Ribble Valley Borough Council
Council Offices
Church Walk,
Clitheroe
Lancashire
BB7 2RA

Phone: 0300 123 6780
Email: developeras@lancashire.gov.uk
Your ref: 3/2026/0341
Our ref: 3/2026/0341/HDC/KW
Date: 16 June 2026

Location: Foxfields Country Hotel Whalley Road Billington BB7 9HY
Proposal: Proposed erection of three no. single-storey leisure facility buildings within the hotel grounds.
Grid Ref: 371634 435031

Drawing Title
Proposed Site Plan

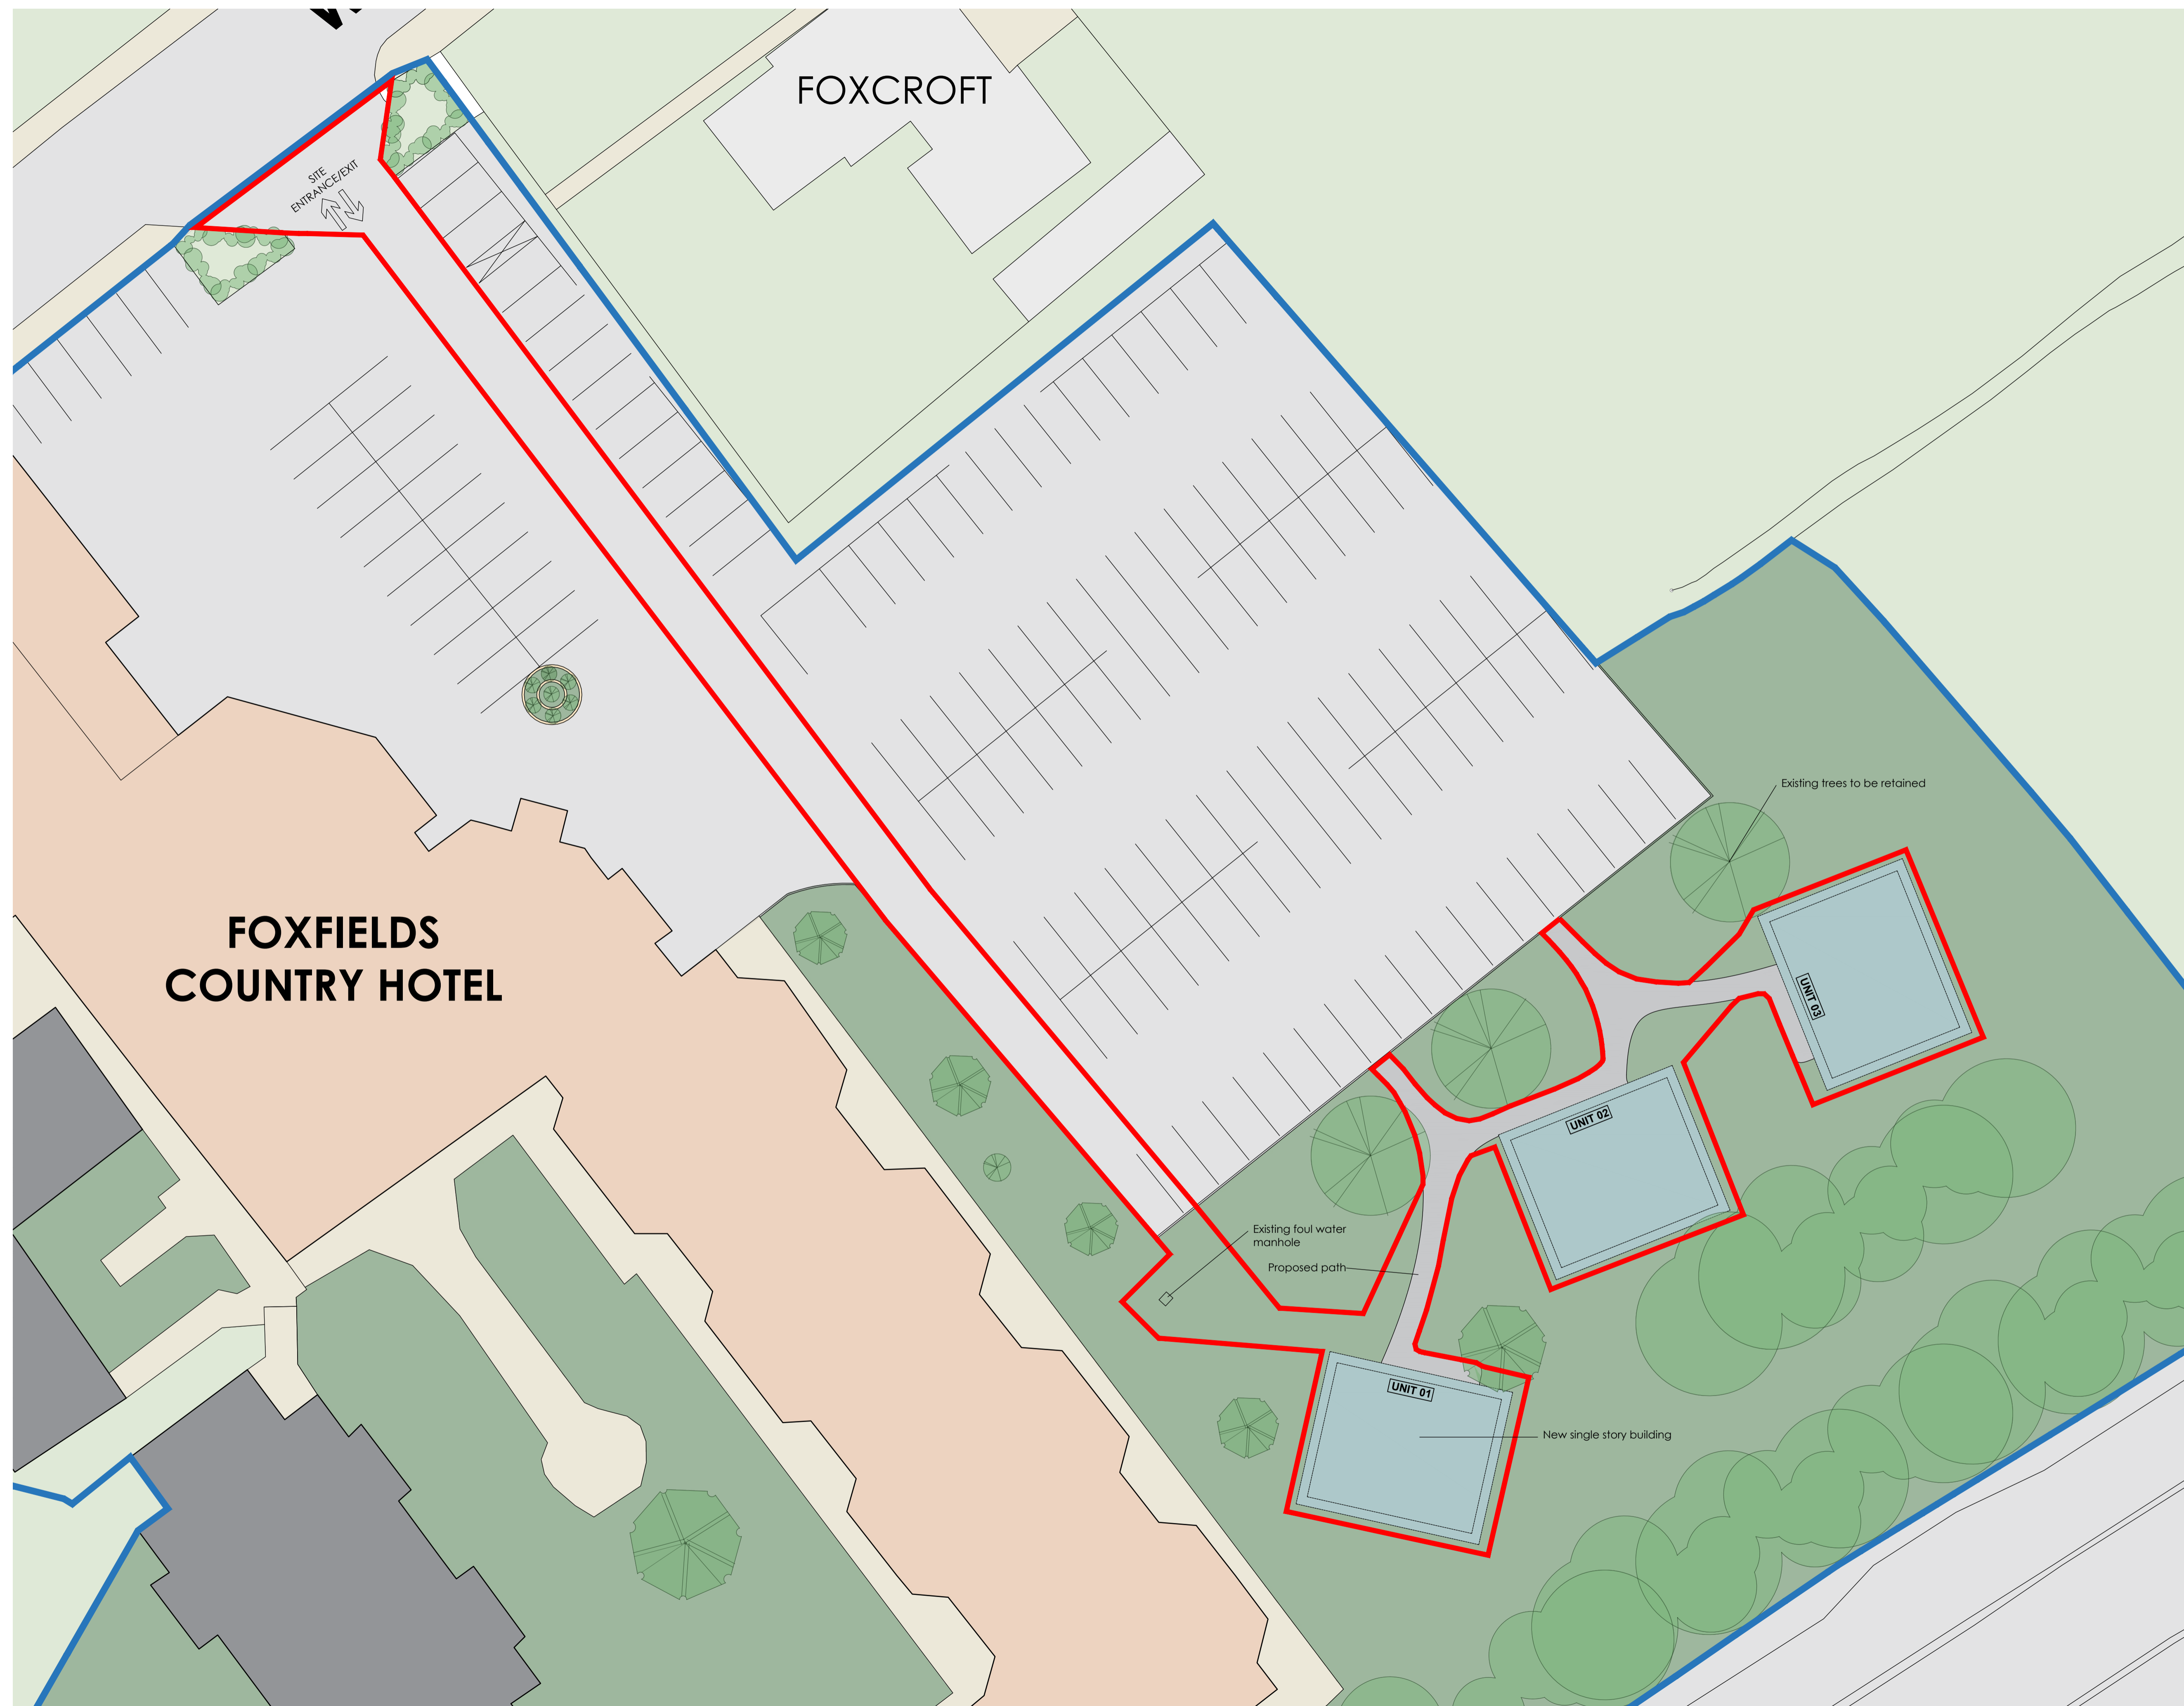
The LHA would, however, recommend that the proposed path around the new buildings link to the stone flags featured around the main hotel building rather than to the car park,

to provide a segregated pedestrian route and remove possible conflict with manoeuvring vehicles in the car park.
